KIRKLEES METROPOLITAN COUNCIL INVESTMENT & REGENERATION SERVICE

DELEGATED DECISION TO DETERMINE APPLICATIONS FOR CONSENT, AGREEMENT OR APPROVAL REQUIRED BY CONDITION

Reference No:	2023/44/90773/W
Site Address:	Land at, Penistone Road, Fenay Bridge, Huddersfield, HD8 0AW
Description:	Discharge of conditions 4 (highway works), 5 (right turn lane), 6 (internal adoptable estate roads), 8 (retaining walls/structures), 9 (surface water), 10 (highway survey), 11 (surface water and land drainage), 12 (storm events), 13 (temporary surface water drainage), 15 (archaeological evaluation), 16 (levels), 18 (Biodiversity Net Gain Assessment) and 19 (EDS) of previous permission 2020/90725 for erection of 68 dwellings with associated access, parking and open space (revised plans)
Recommending Officer:	Nick Hirst

DECISION – Discharge of Conditions – Split Decision

Headwall HW1 - 150mm Ø Incoming Pipe

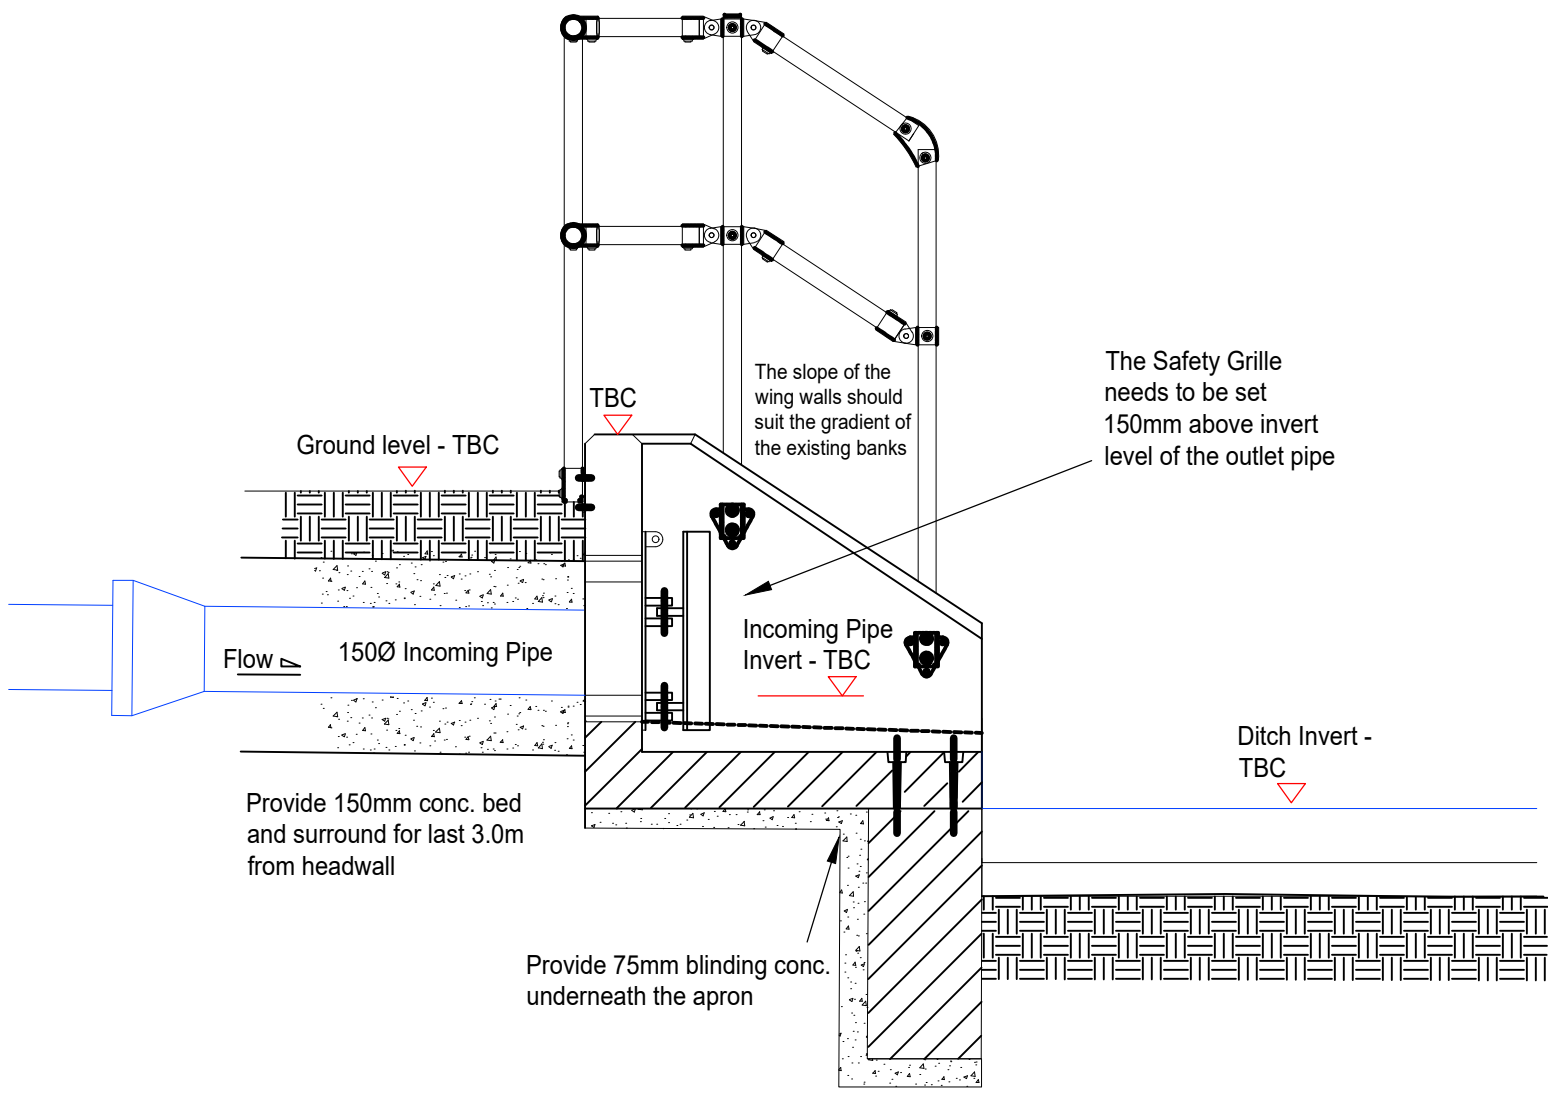
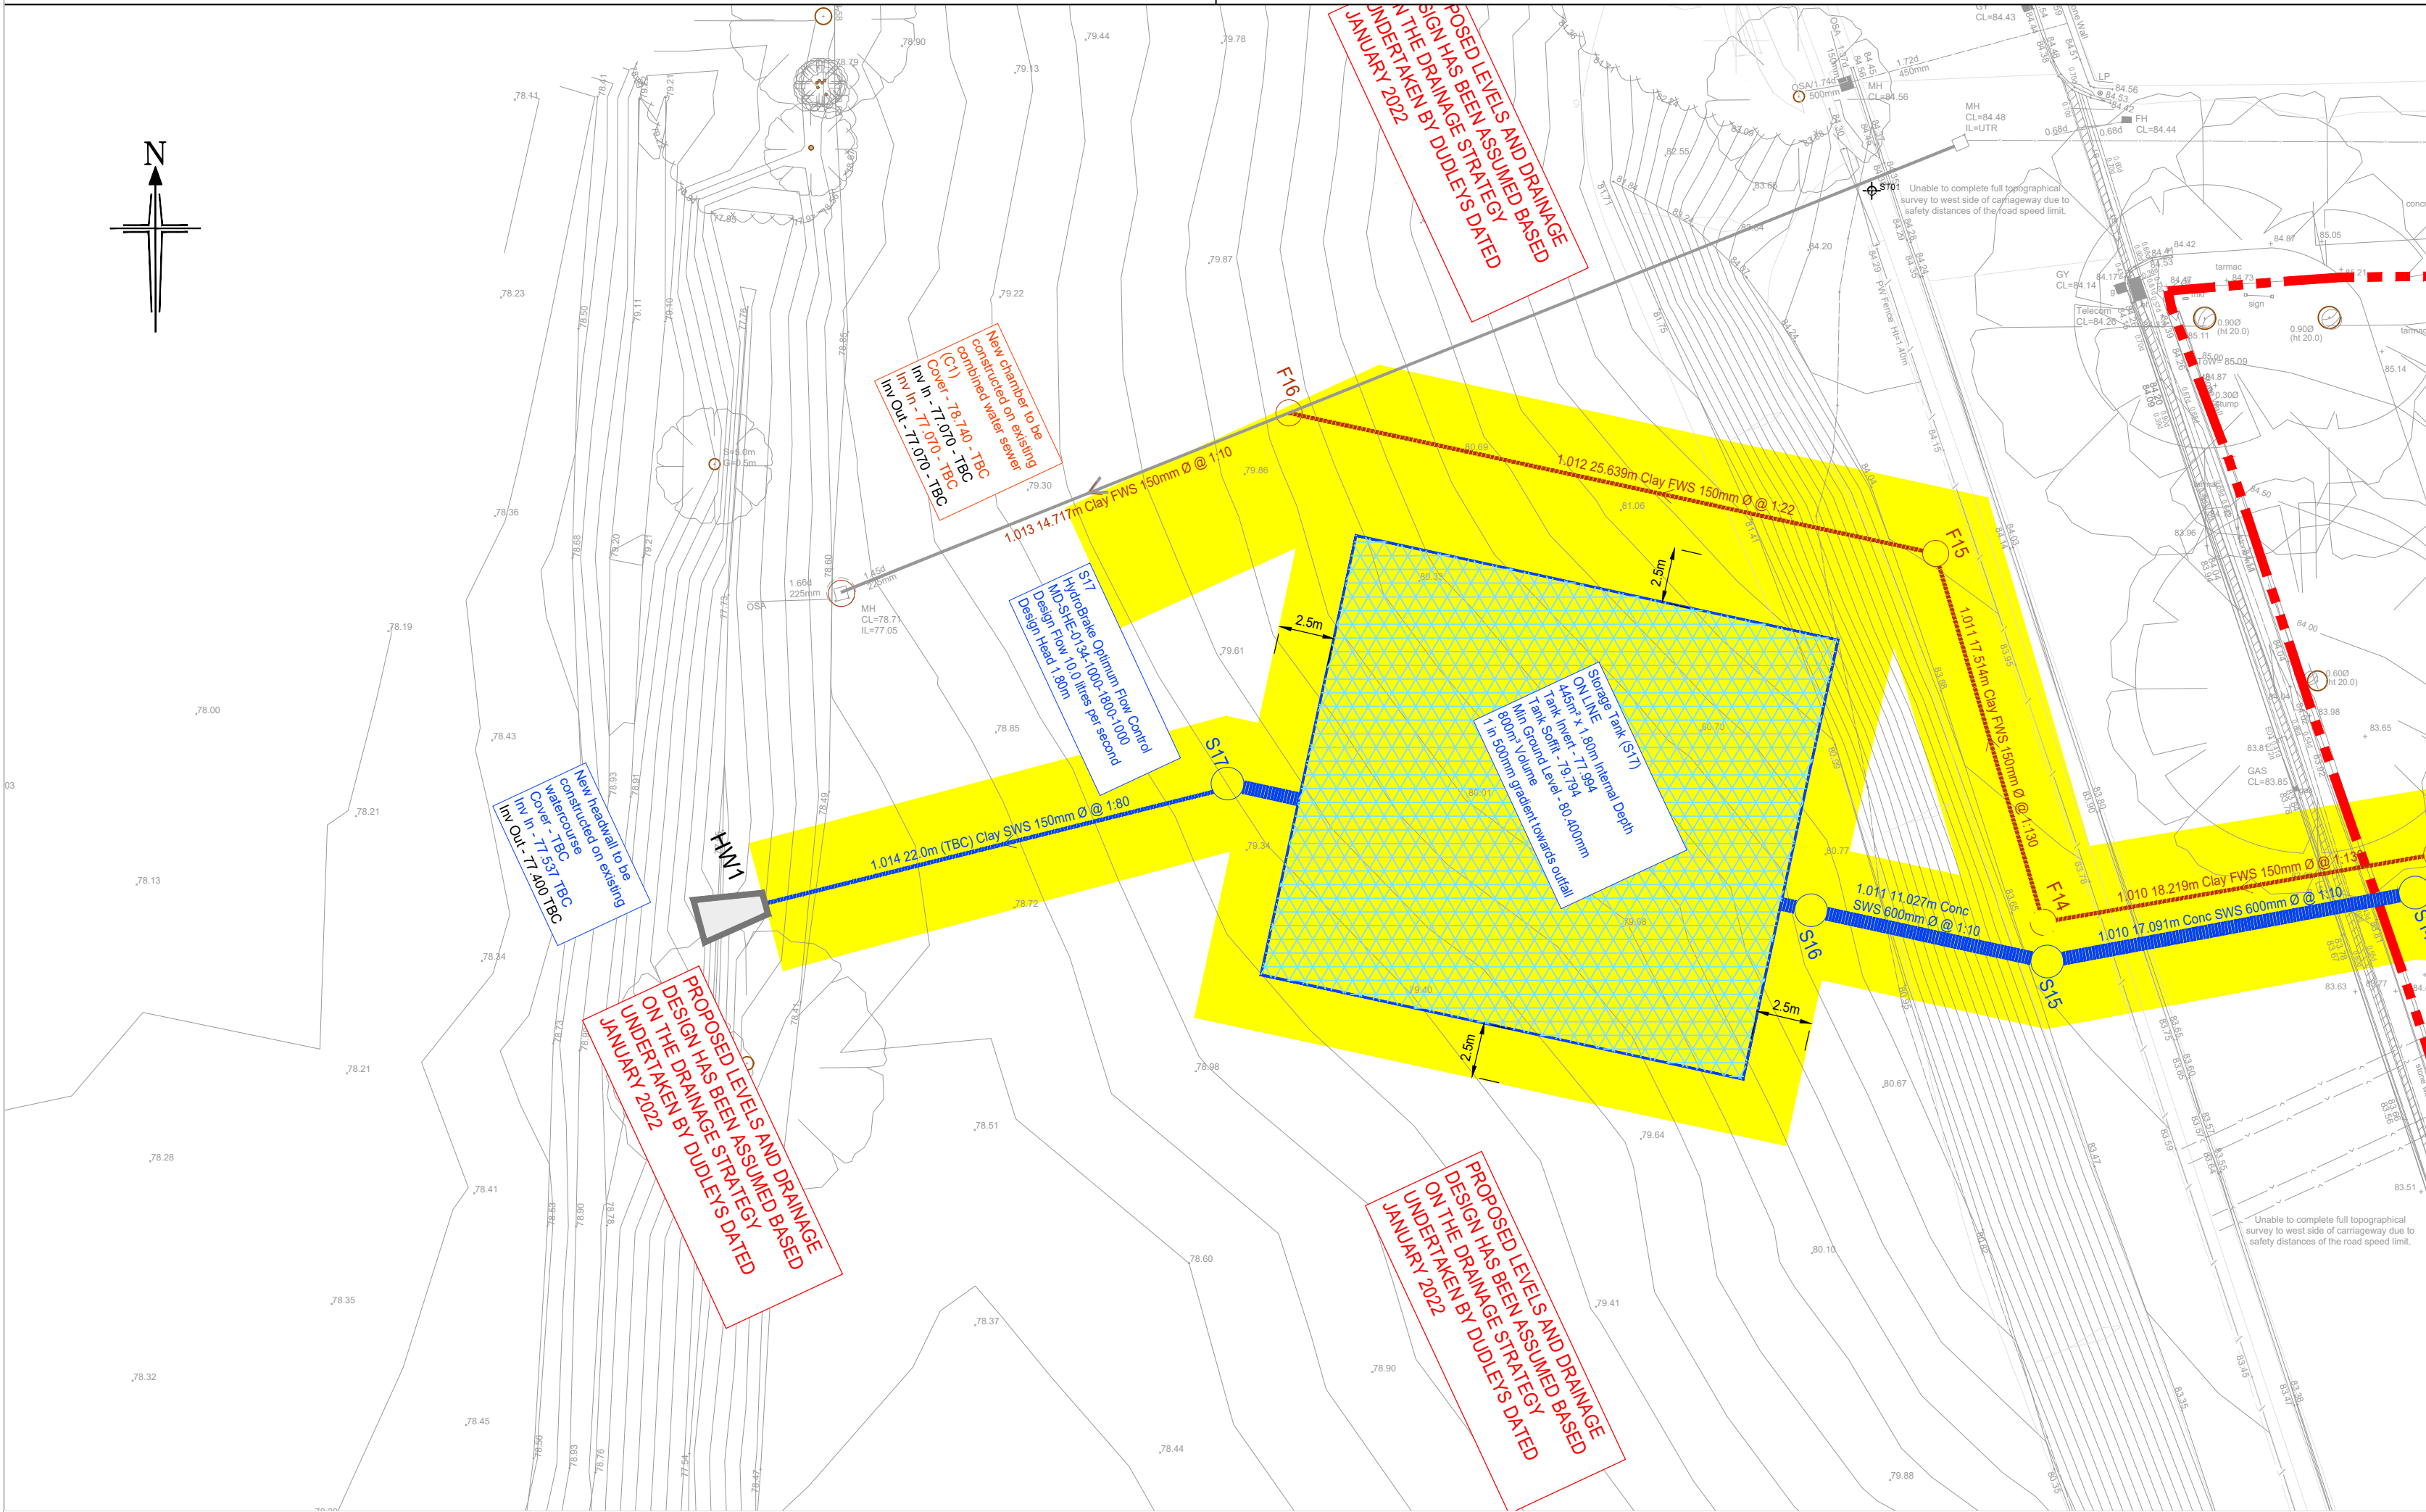
This will require the submission of detailed and fully dimensioned X-sectional details so as to determine whether the design of proposed culvert headwalls on the A629 Penistone will be liable to a formal technical approval (AIP). In addition, the design of all oversize PCC manholes (ID > 900mm) will be liable to approval via certification, as stated in <https://www.kirklees.gov.uk/beta/regenerationand-development/pdf/highways-structural-procedures.pdf>.

Drawing No: 22/491/FST/EXT/001 Revision:
Job No: 22-491 Date: 19.12.22

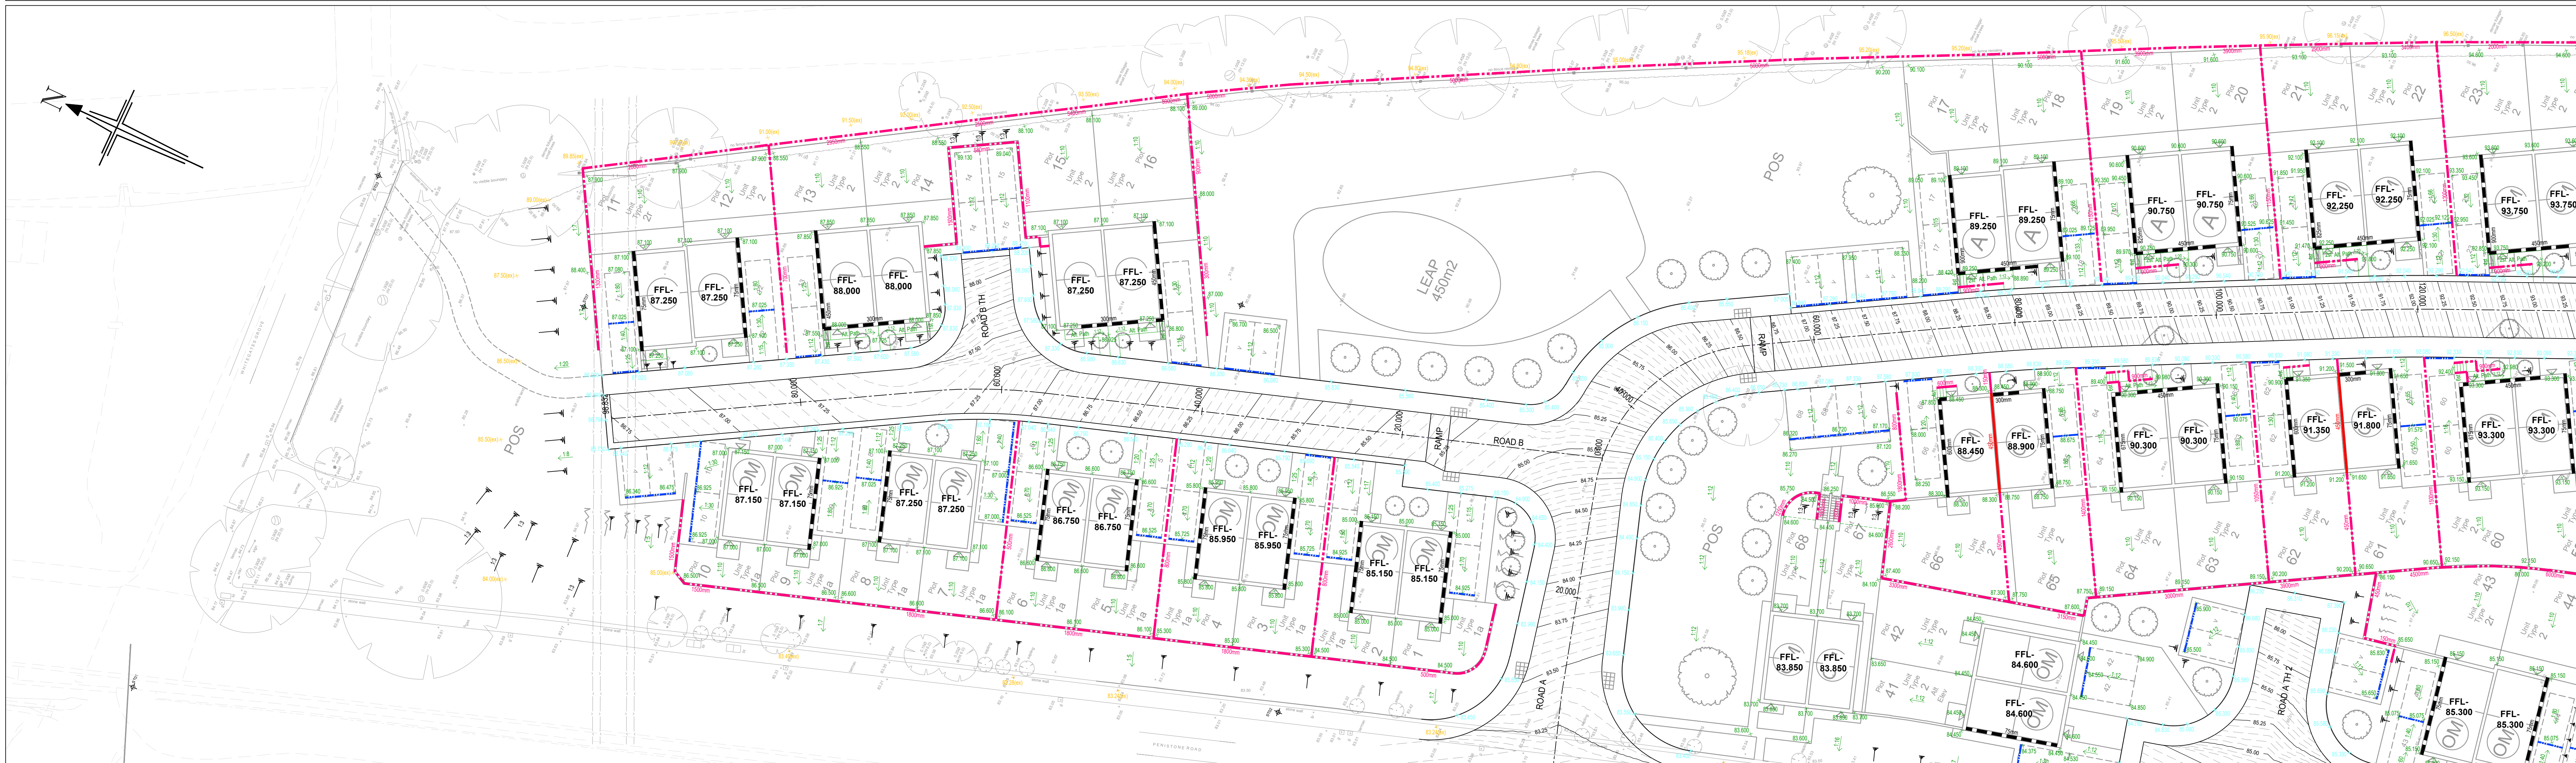
The proposed levels are intrinsically linked to the proposed internal road works which, as set out above, cannot currently be supported. Therefore, it would be premature to support the details pursuant to condition 16 until condition 4 is resolved, so as to inform the site's wider levels.

Furthermore, limited cross sectional details have been provided. What has been submitted does not adhere to the condition's requirement for:

Based on the (inadequate) details held, officers have specific concerns over the extent and scale of the retaining walls, and the impact they may have on the amenity of existing and future residents. Without the further details required to enable a more thorough assessment, officers are unable to support the submitted details.
